RFI

RFI #: 115
Date: 5/14/2012
Job: EB-02 Keller Springs Lofts
Phone: 877-777-5115

Subject: HVAC Supply Duct and Return Air Duct Locations

RFI #: 158
Date: 6/15/2012
Job: EB-02 Keller Springs Lofts
Phone: 877-777-5115

**2.3A**

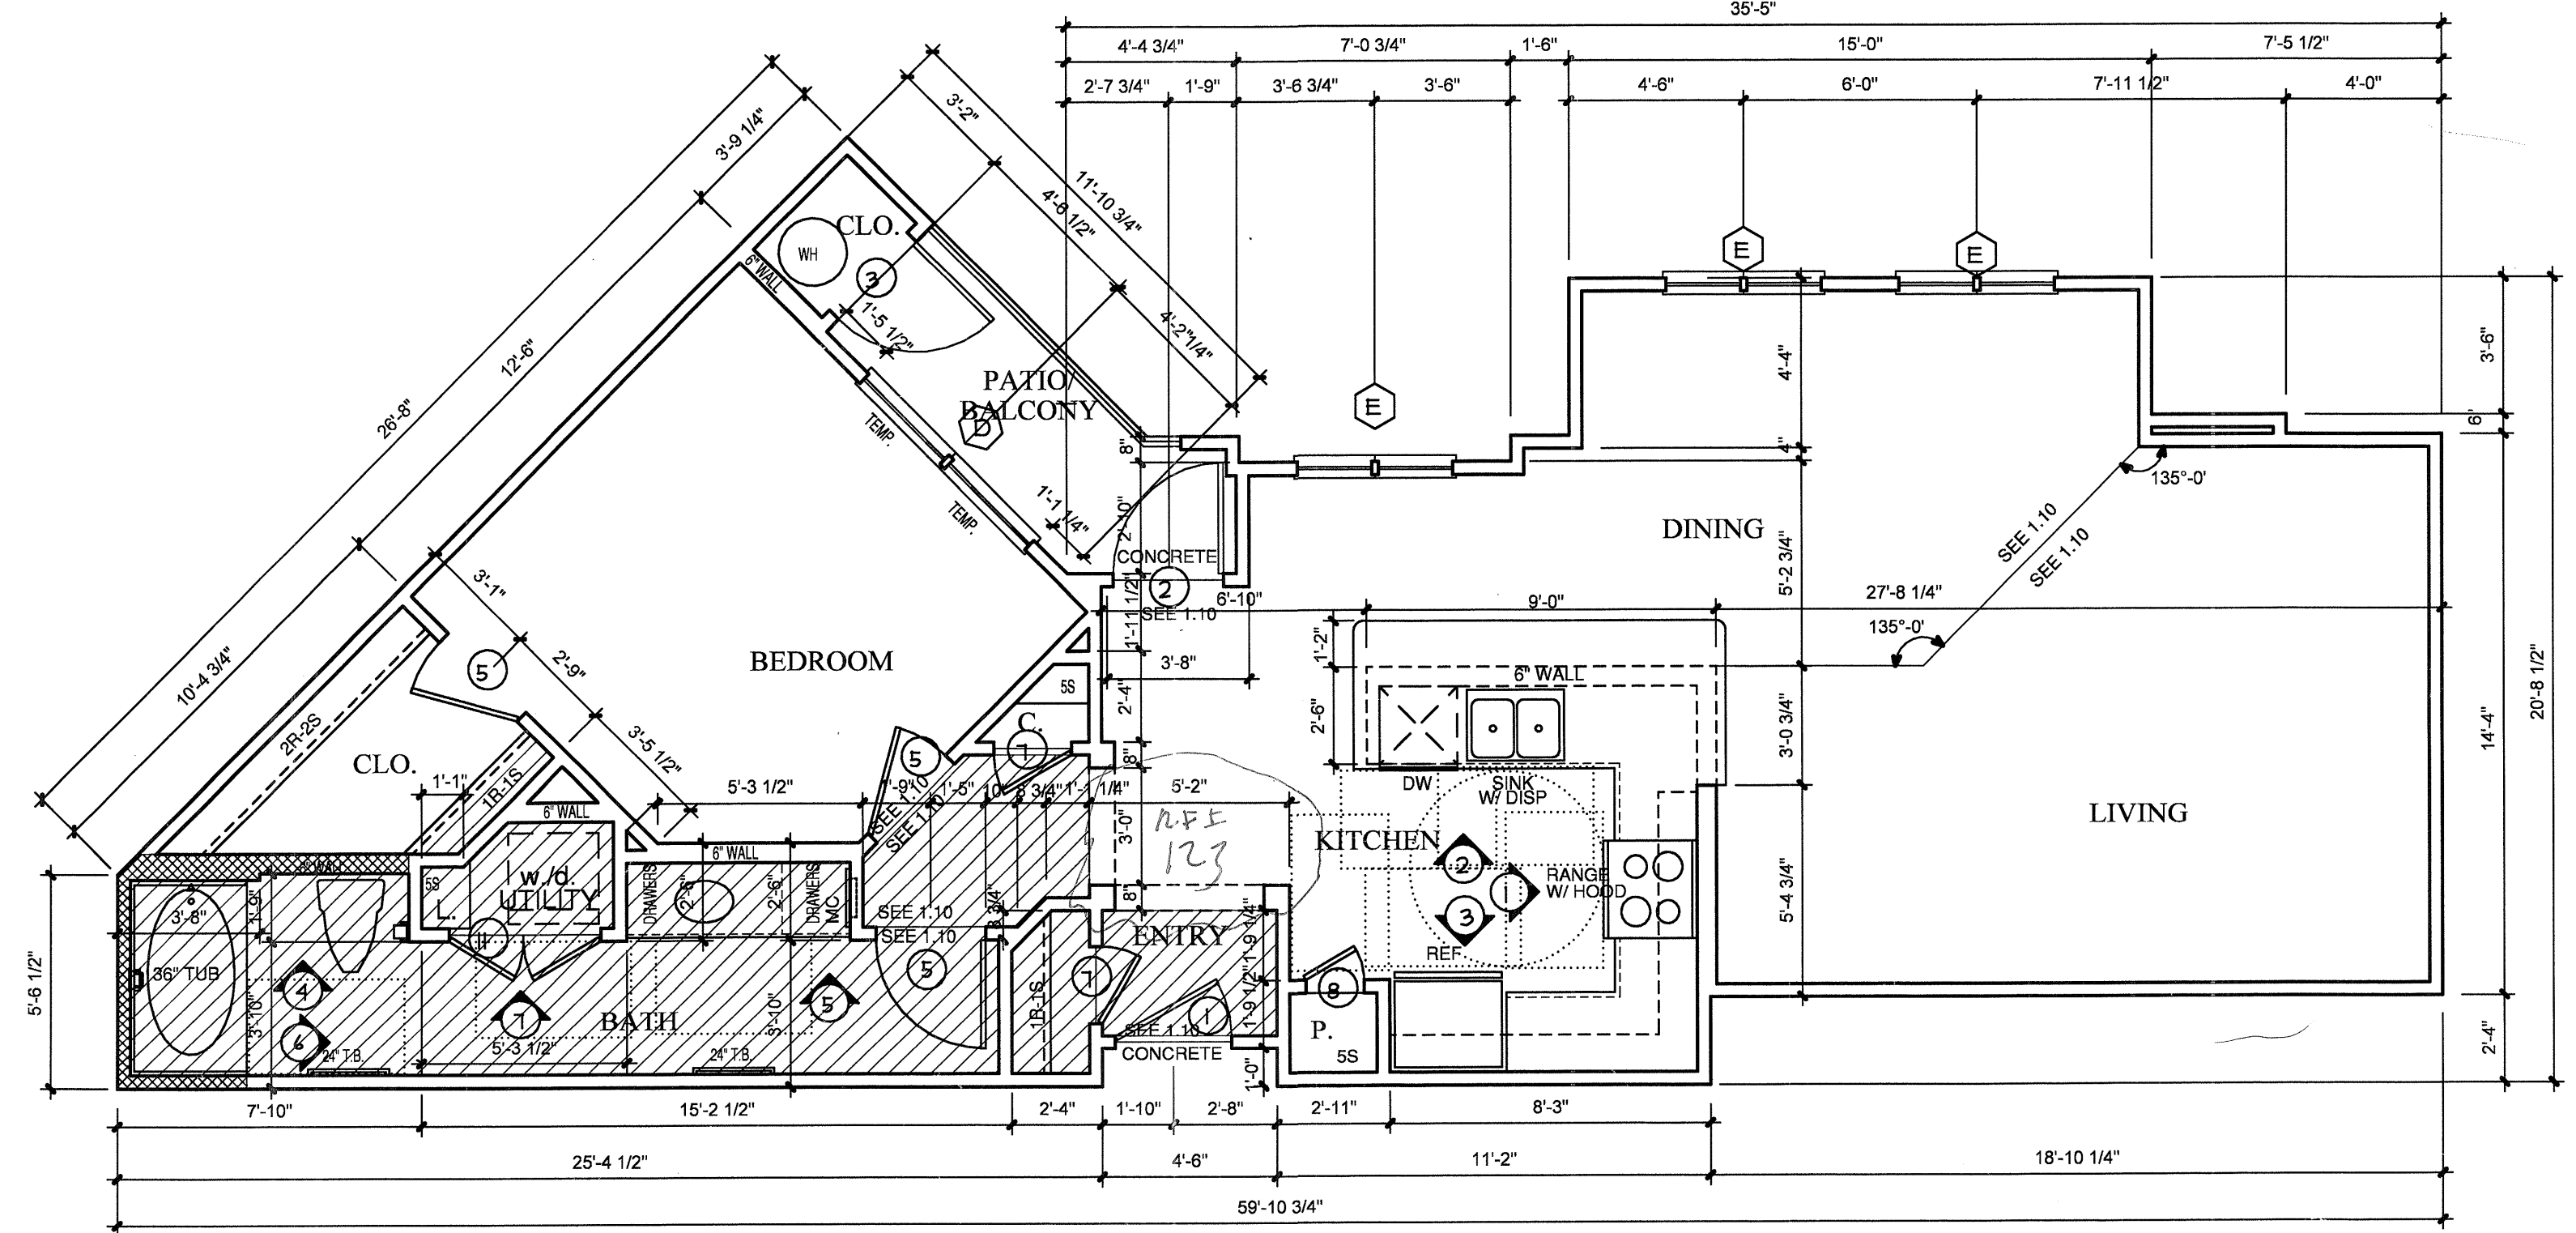
Request: **Date Required:** 6/22/2012
4/M-2.2 shows no fur down over washer/dryer unit in A2-SP, sheet 2.3A shows A2-SP with fur down. Please clarify and advise.

No furrdown is required over the washer/dryer.

SHEET NUMBER
M-2.1
E1 &
A1 UNIT
MECHANICAL

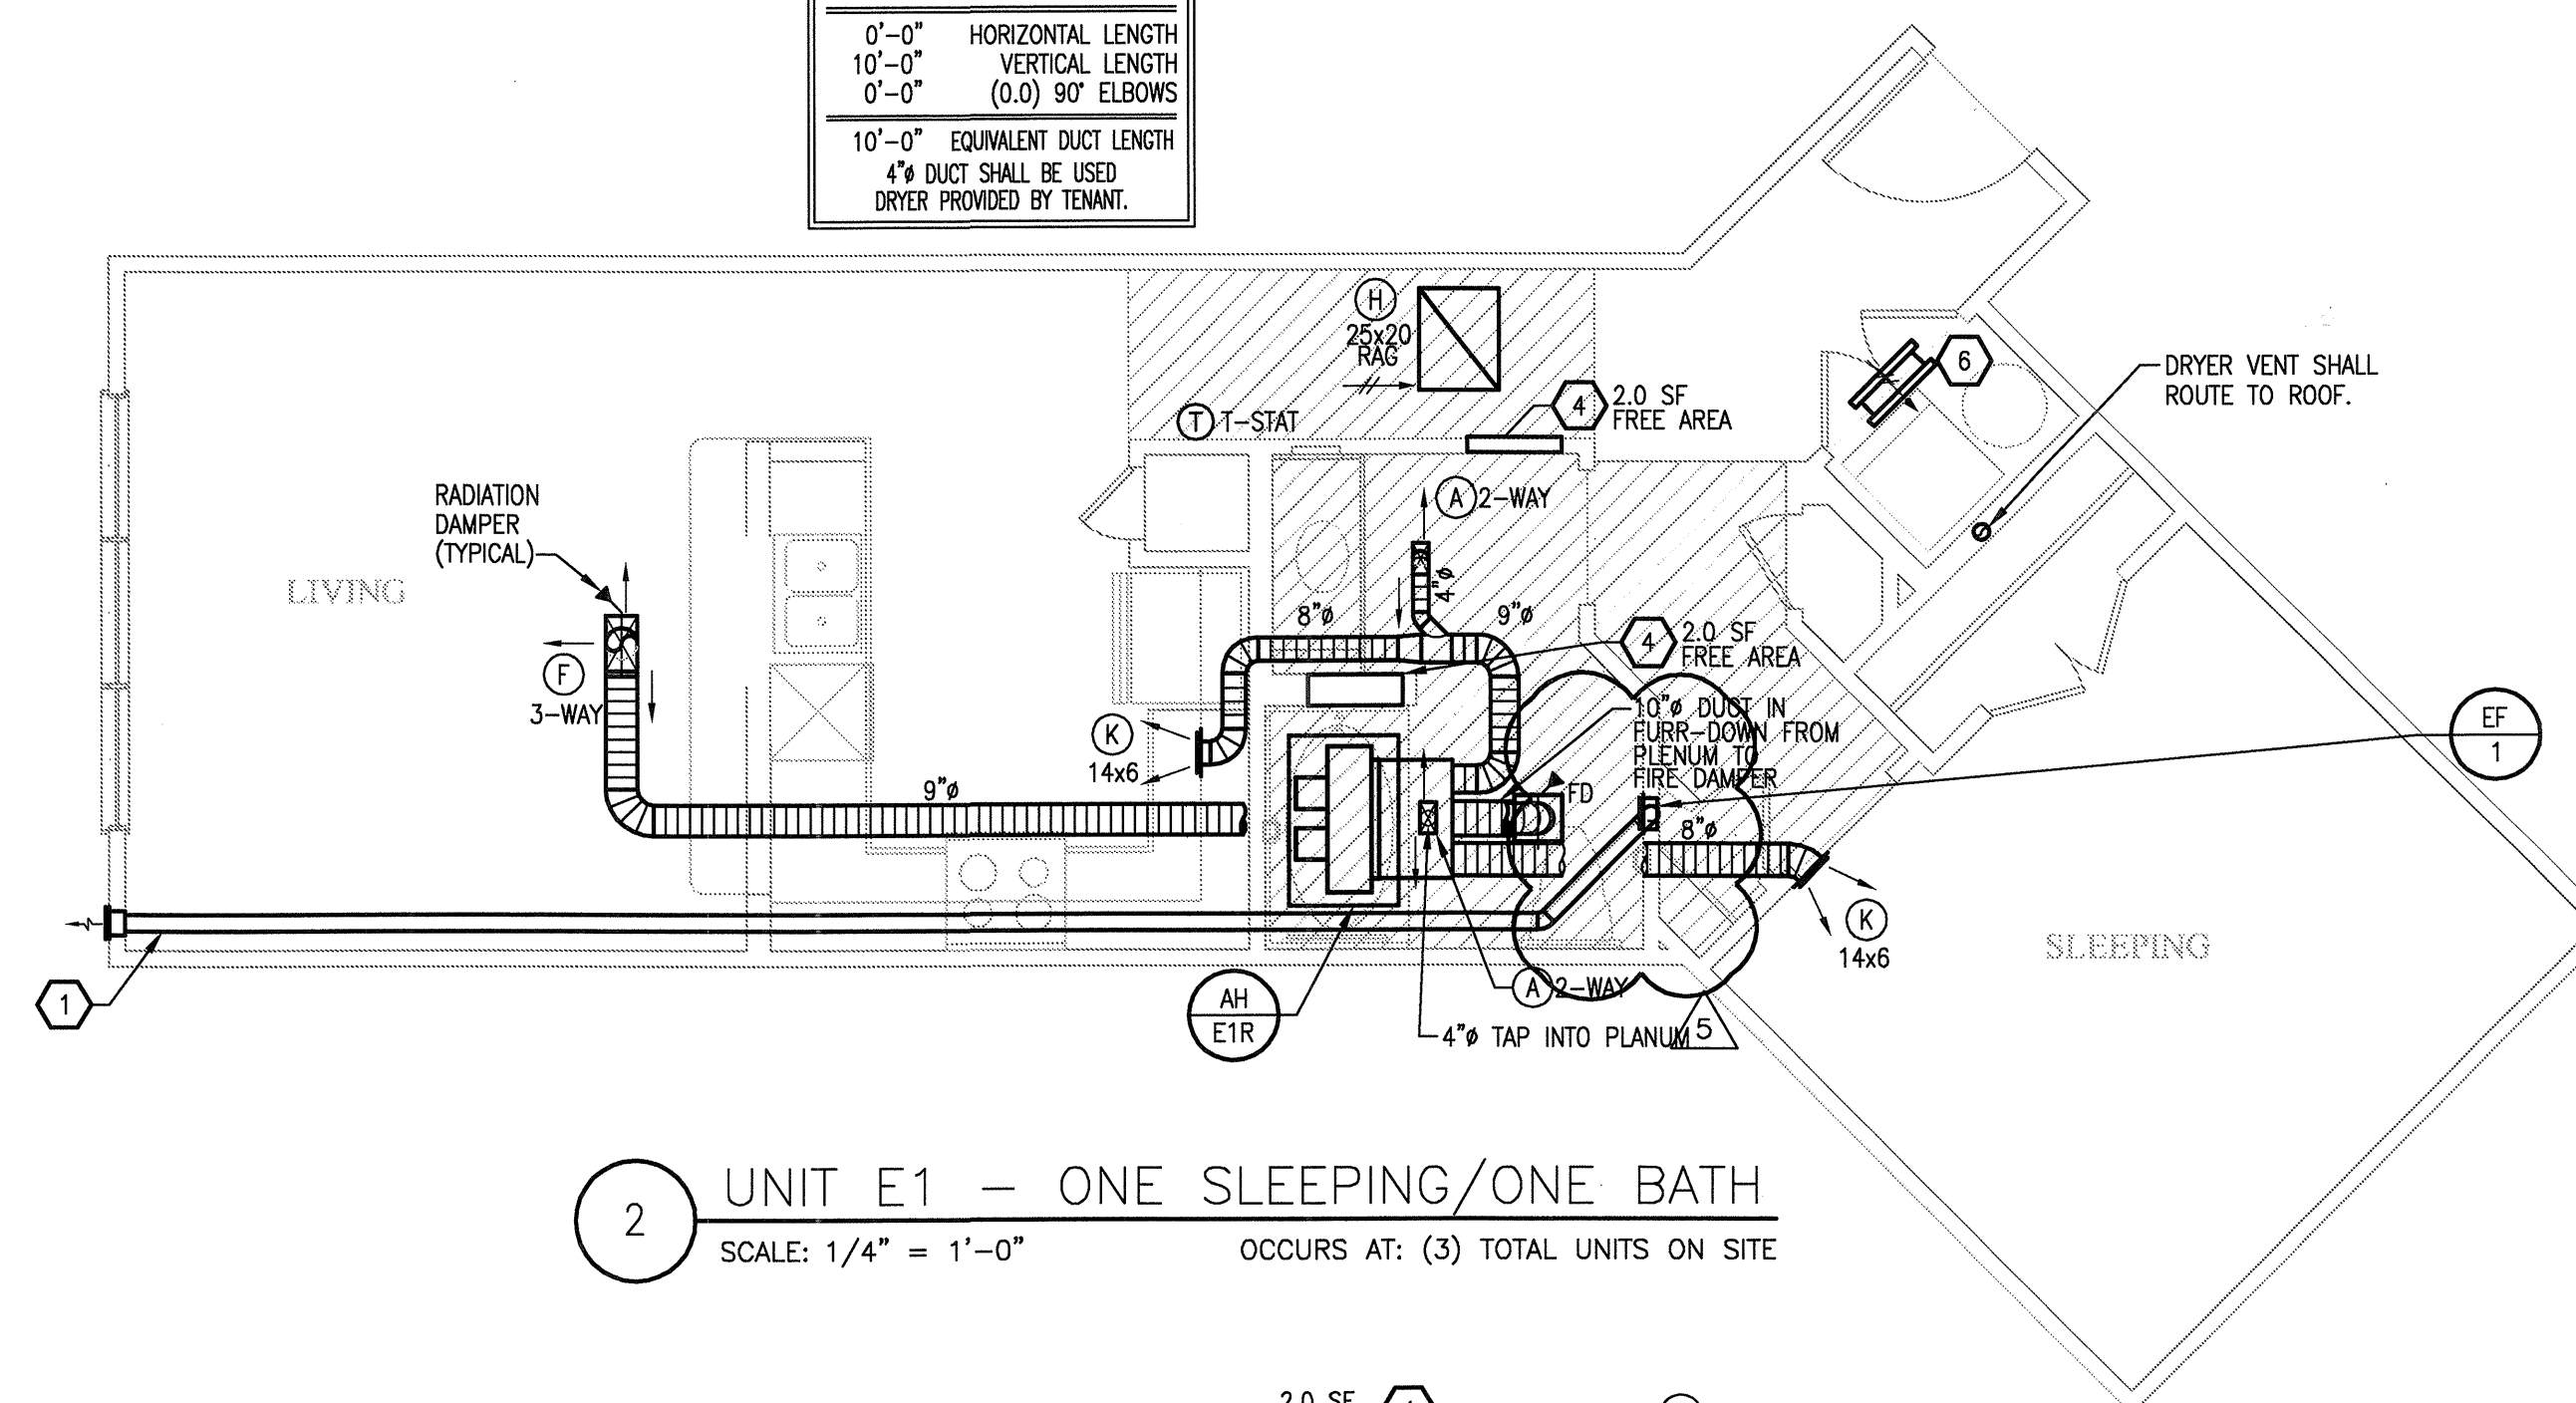
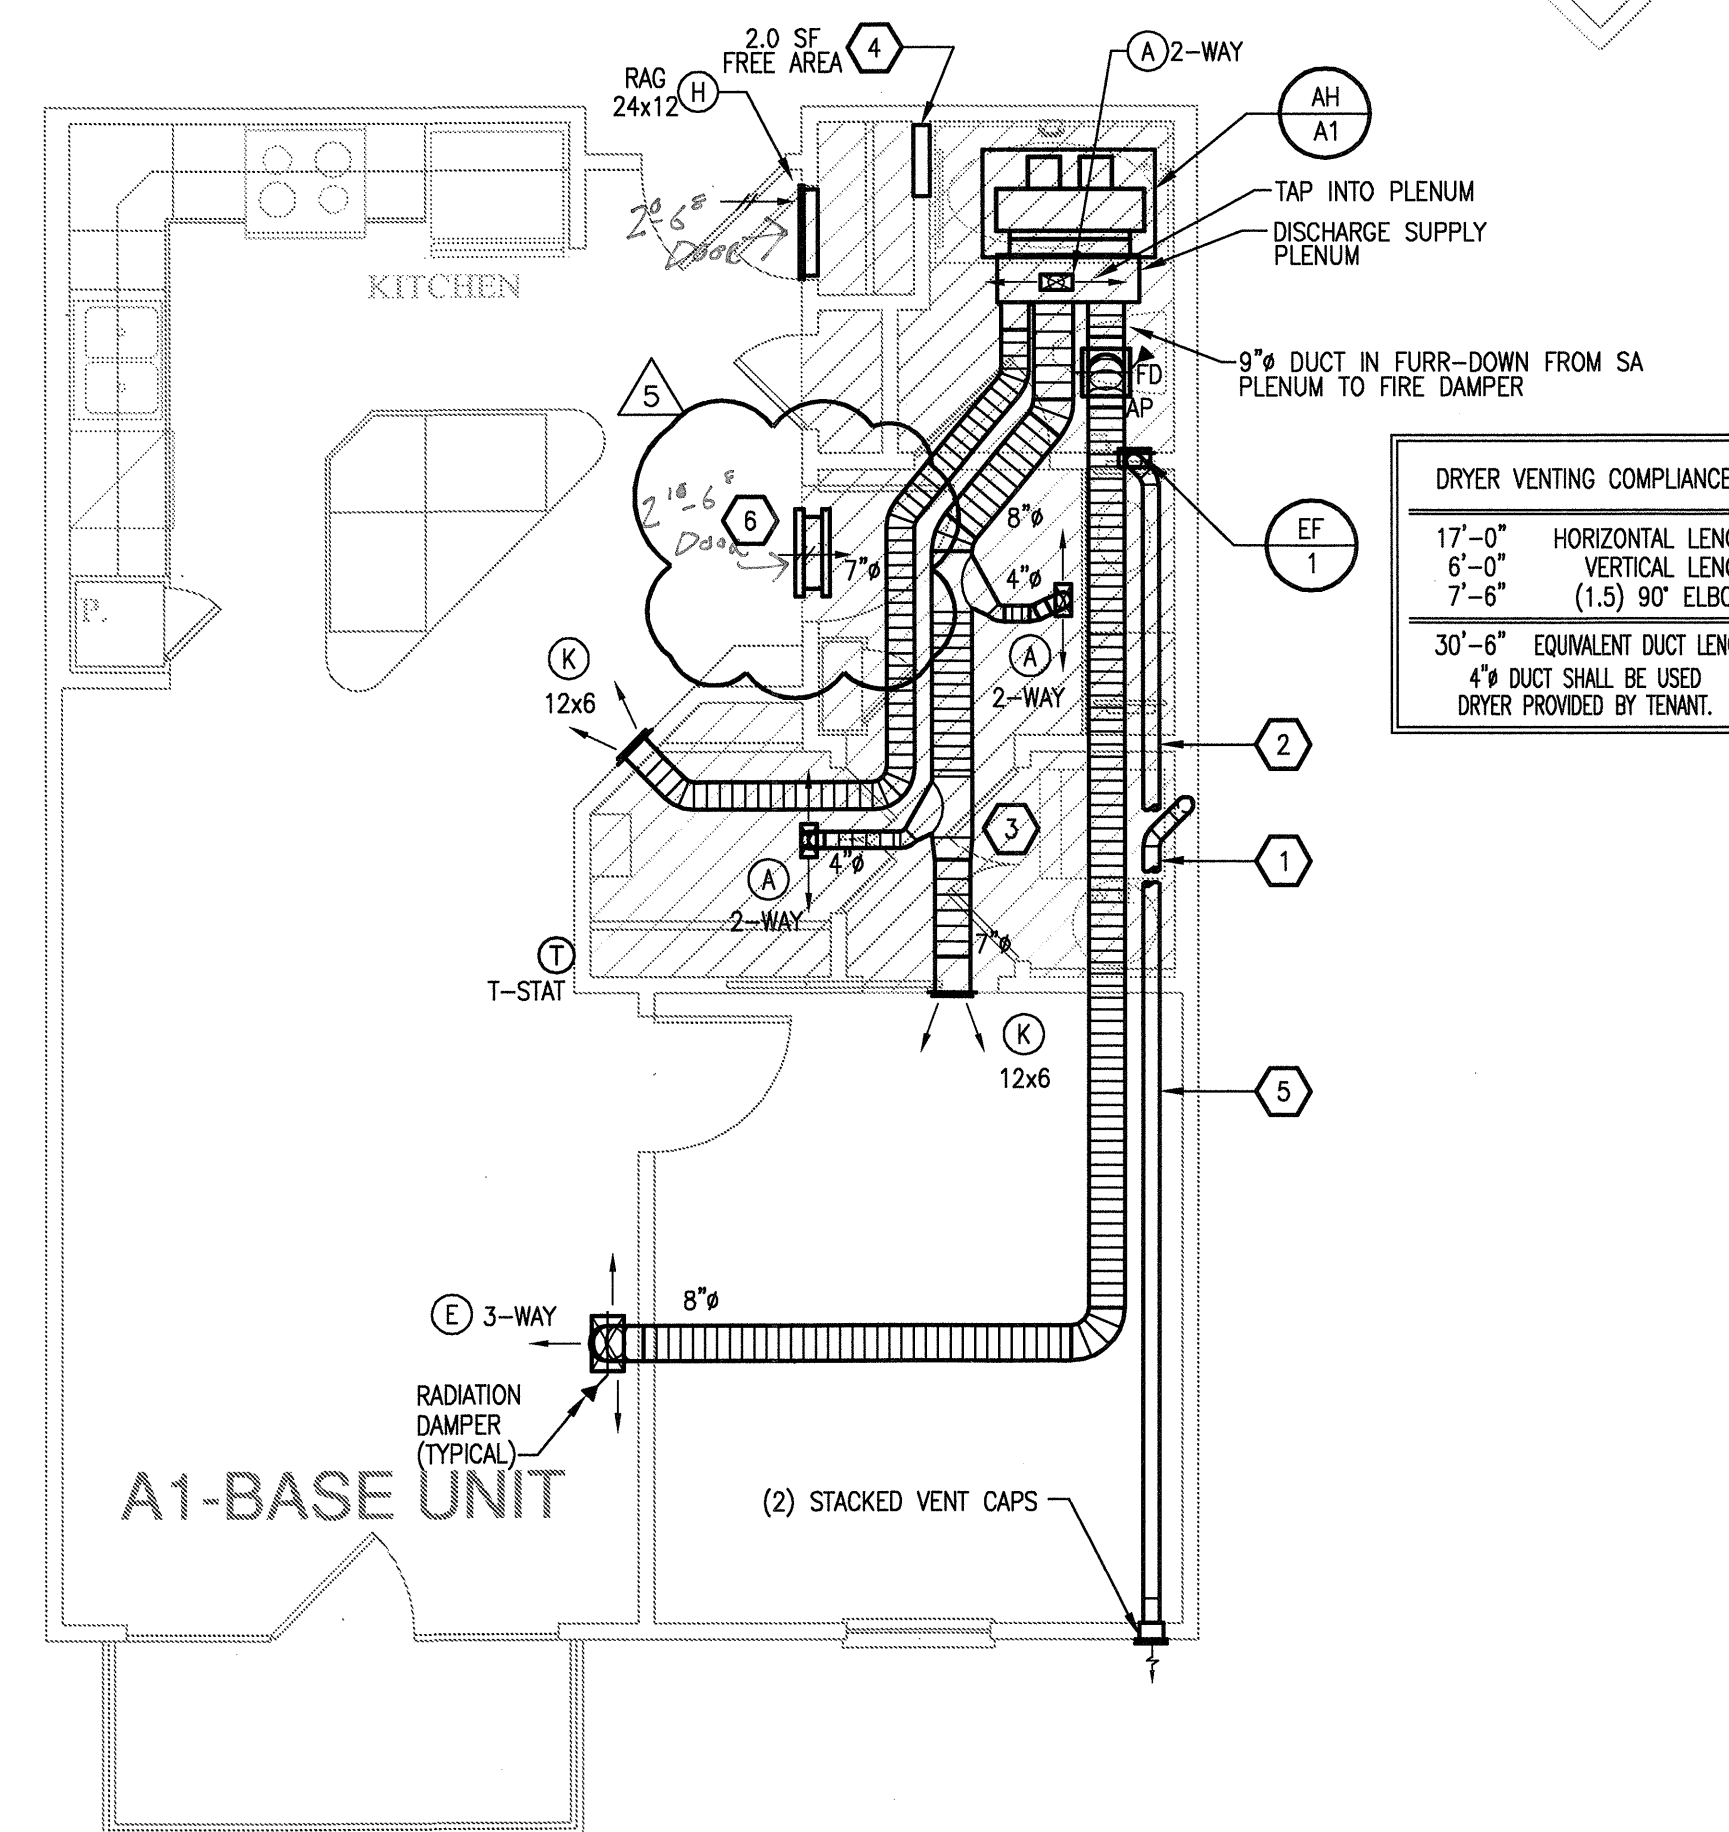
Request: **Date Required:** 5/22/2012
In the A1, A2, A4 and B2 unit types, there are either supply ducts or return air ducts terminating in a load bearing wall. Please provide a way to get around this issue.

Refer question to Architect and/or Mechanical Engineer for additional requirements necessary for penetrating a load-bearing wall.

Provide a type A header where duct penetration will not fit between the stud wall framing.
